Consultation Response from: KC Environmental Health (Pollution & Noise Control)		
2019/90988 - Land adj, lock 38, Marsden Lane, Marsden, Huddersfield, HD7 6AF		
Use of land for provision of camping facilities, formation of camper van and tent sites, erection of 5 camping pods, toilet block and wood store and associated works		
Date Responded: 20 Dec 2019	Responding Officer: Richard Hume	Responding Ref: WK/201907193
In our original consultation response dated 14 May 2019 we commented on our concerns about the application that we considered would be likely to lead to an intensification of the use of the site increasing the potential for causing loss of amenity to nearby residents from smoke from open fires and noise such as from excessively loud music. We advised that a detailed noise and smoke management plan would be required. We also advised of concerns regarding the lack of detail about the proposed foul drainage provisions for the site, again advising that more details were required. We also recommended the provision of electric vehicle charge points. Additional information relevant to our comments has now been provided in the following documents:- • A statement in support of th

A: 28/03/2019 - TIMBER STORE ADDED	
PROPOSED CAMPING SITE AT LAND ADJACENT LOCK 38, OFF MARSDEN LANE, MARSDEN HD7 6AF FOR S.B. HOMES LTD	
PROPOSED SITE PLAN ~ SCALE 1:200 (A1)	
WILLIAM BEST RIBA 22, POLE GATE, SCAMMONDEN HD 3 FW3 TEL: 01484 845896.	2018 - 541 - 03 A MARCH 2019.

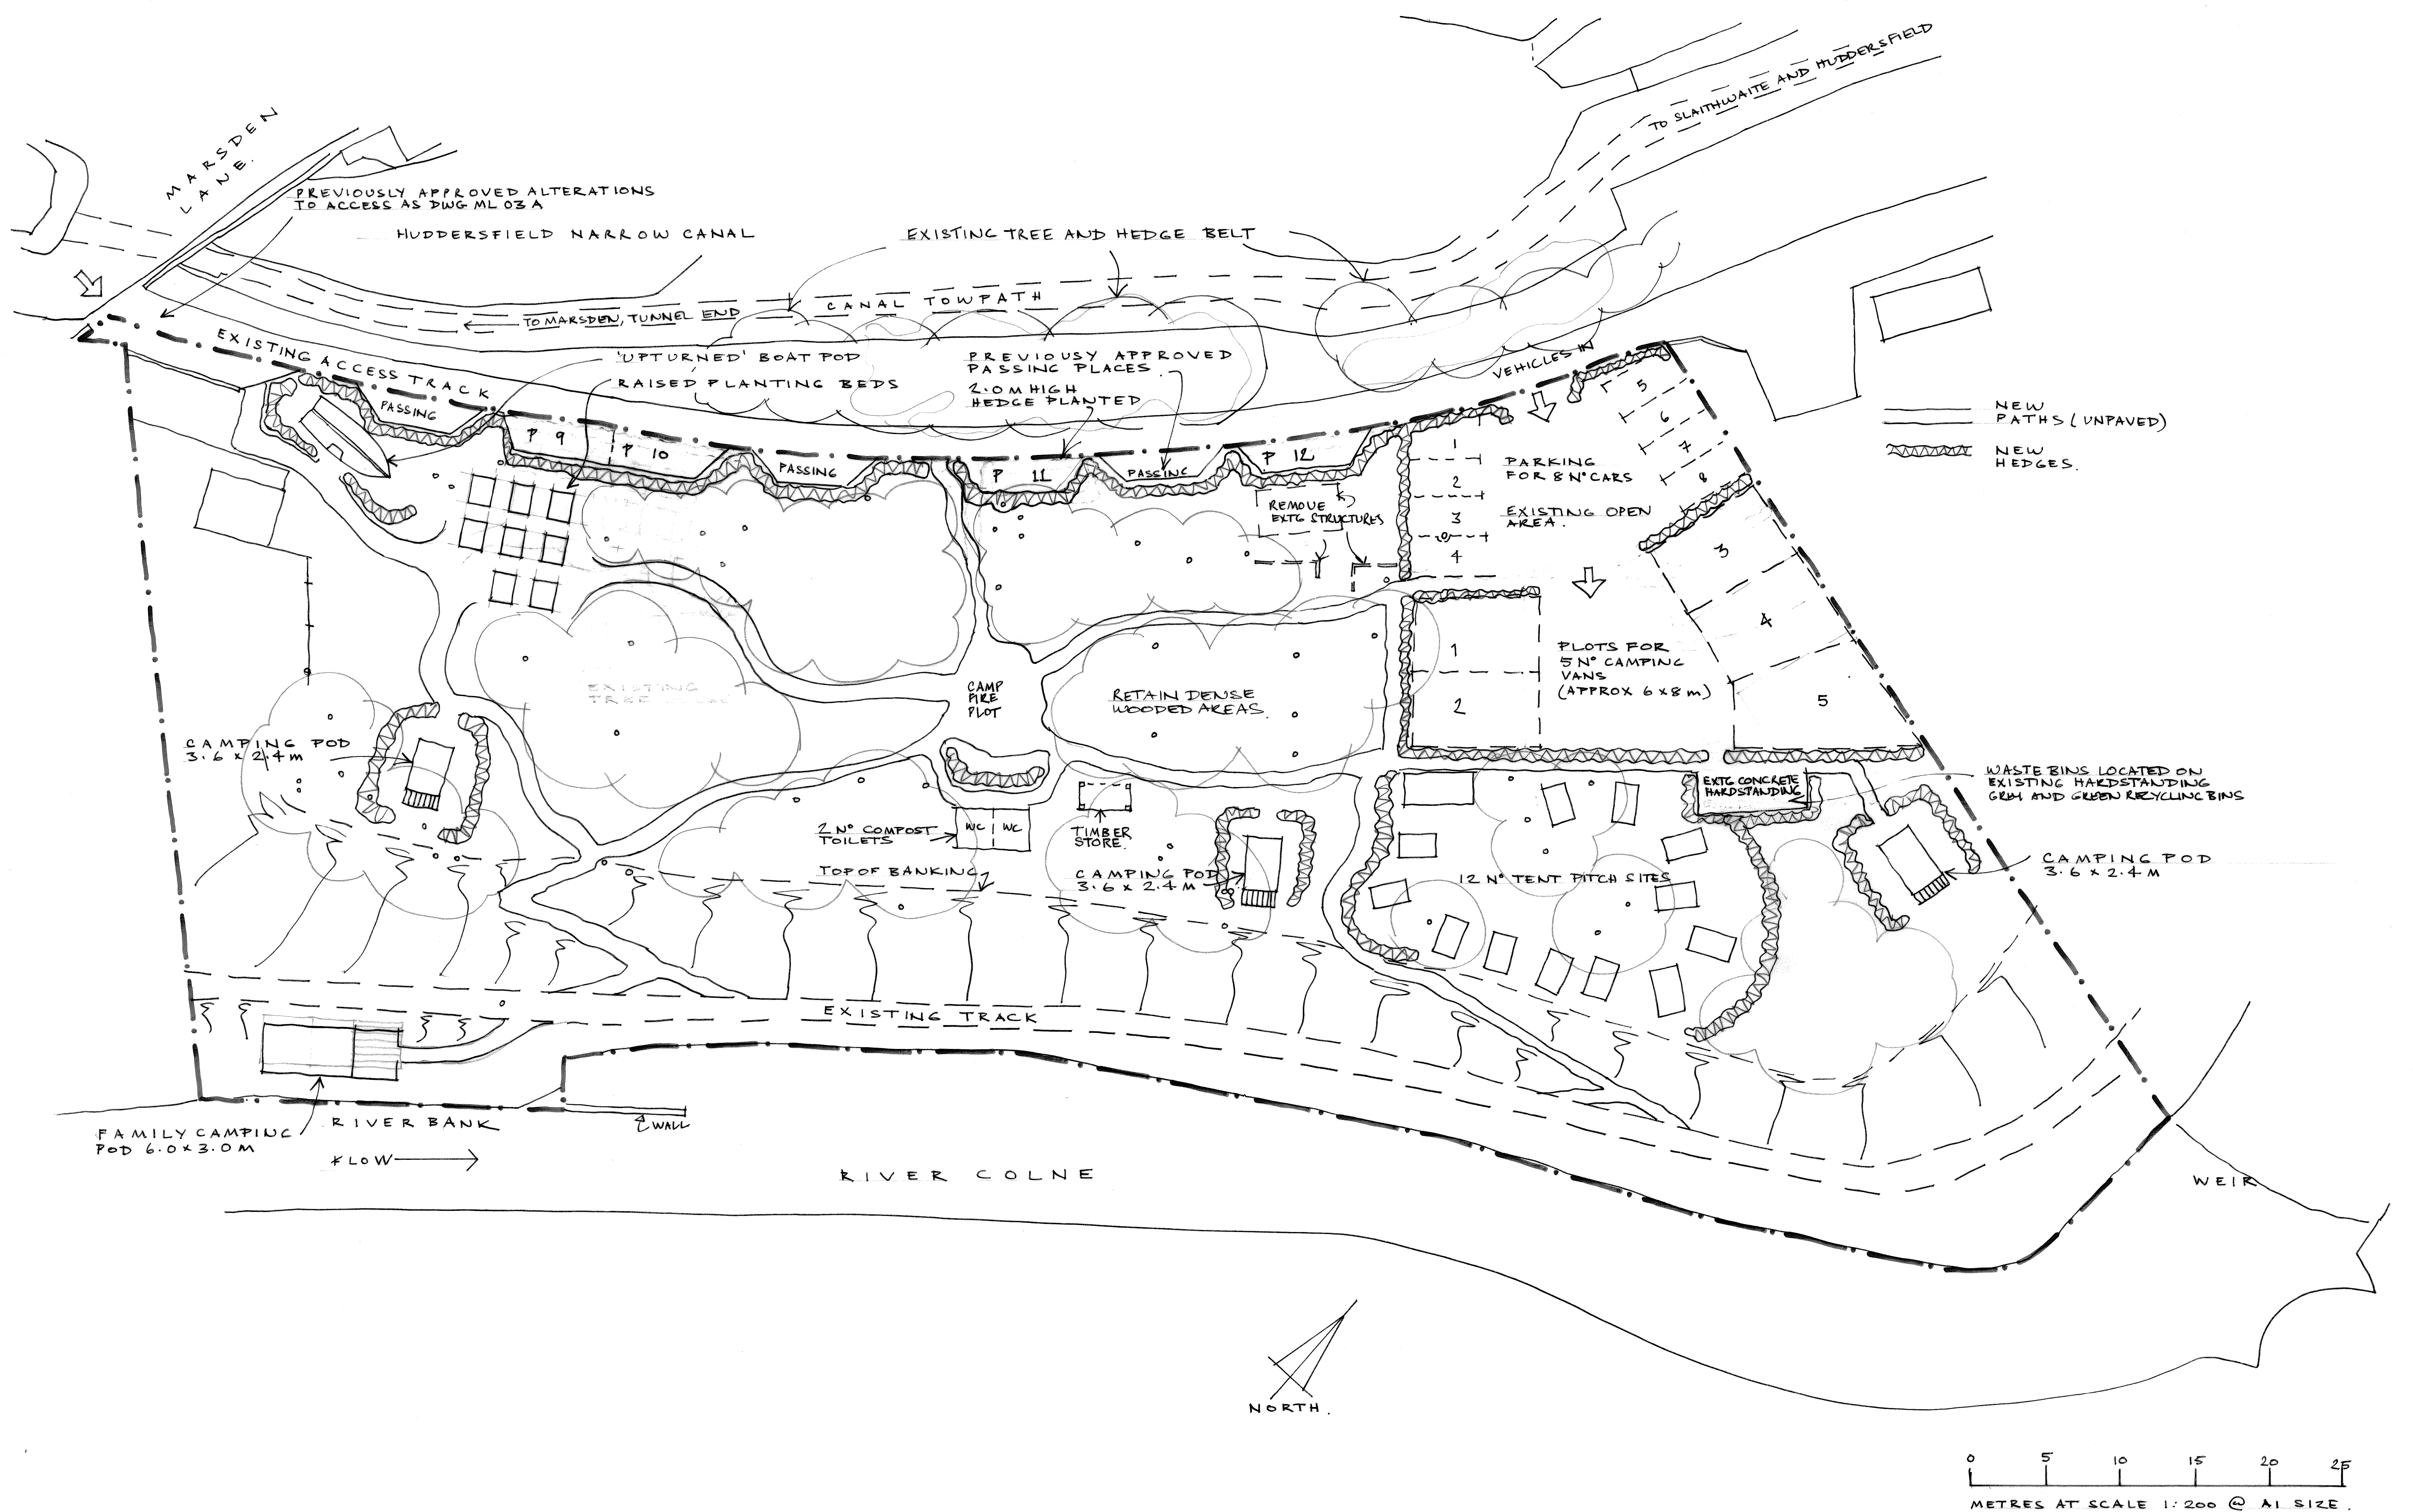
The submitted plan shows the location of two electric vehicle charging points, but no additional information is provided. A detailed specification for the proposed charging points will be required but this can be obtained through a condition.
